**Campaign to Protect
Rural England**
Northamptonshire

PINS ref: EN010170

Application by Green Hill Solar Farm Ltd. for an Order granting Development Consent for a proposed solar development on land between Northampton and Wellingborough

**CPRE Northamptonshire
Feedback on Applicant Responses to Deadline 3 Comments REP3-095
Deadline 5, 12th February 2026**

Title: Figure 8.9.2 Augmented
Zone of Theoretical Visibility (ZTV)
of Full Scheme at Green Hill B
Revision A

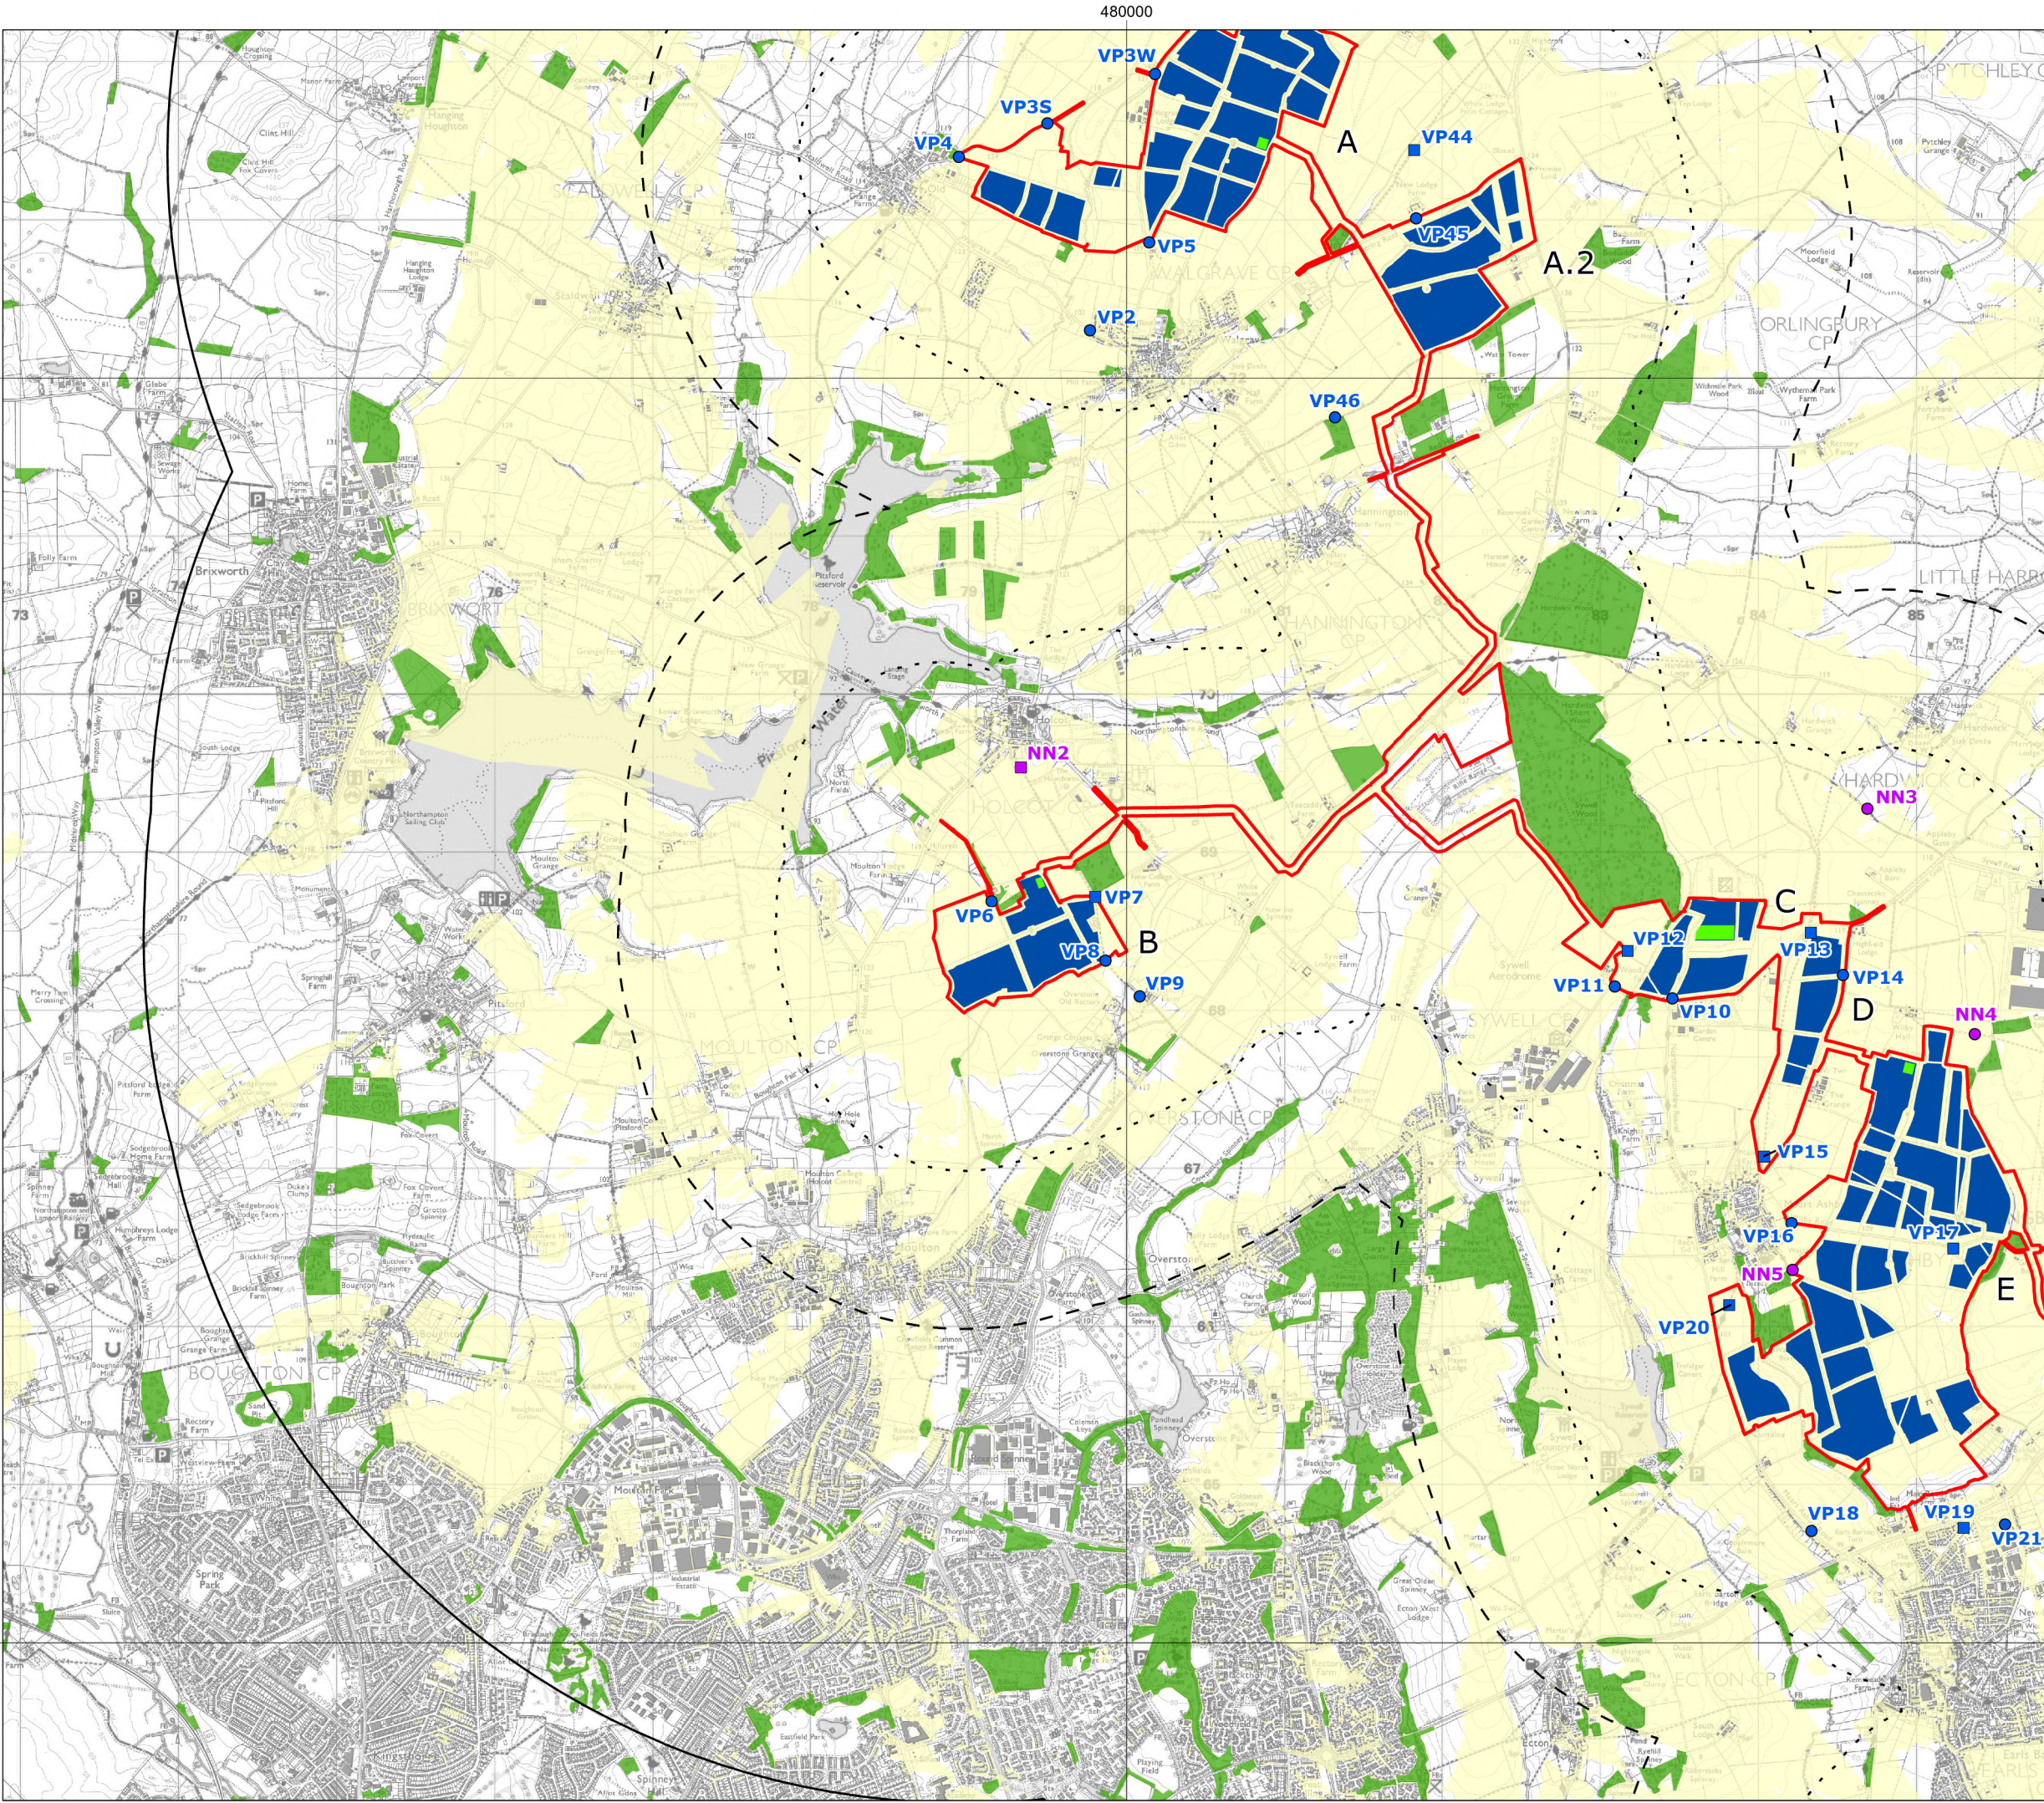
<p>process they are too late to be of benefit to us.</p> <p>Bare earth ZTVs do over-represent visibility but augmented ZTVs are notorious for under-representing visibility because they assume that all features of a certain type are impenetrable and of a certain height across their mapping footprint. If views are predicted on an augmented ZTV they are extremely likely to exist.</p>		
CPRE-024	<p>We maintain that the study areas are unduly restricted in particularly where it applies to cumulative sequential visual impacts. The size of the study areas is less than the sizes used in other applications</p>	<p>A detailed LVIA methodology that conforms to the landscape Institutes Guidelines for Landscape and Visual Impact Assessment (GLVIA3) is included within ES Appendix 8.1 [APP078 & APP079], which has been progressed and agreed with the Local Planning Authorities, this includes the identification of the Study Area for the LVIA.</p>	<p>We maintain our view</p>
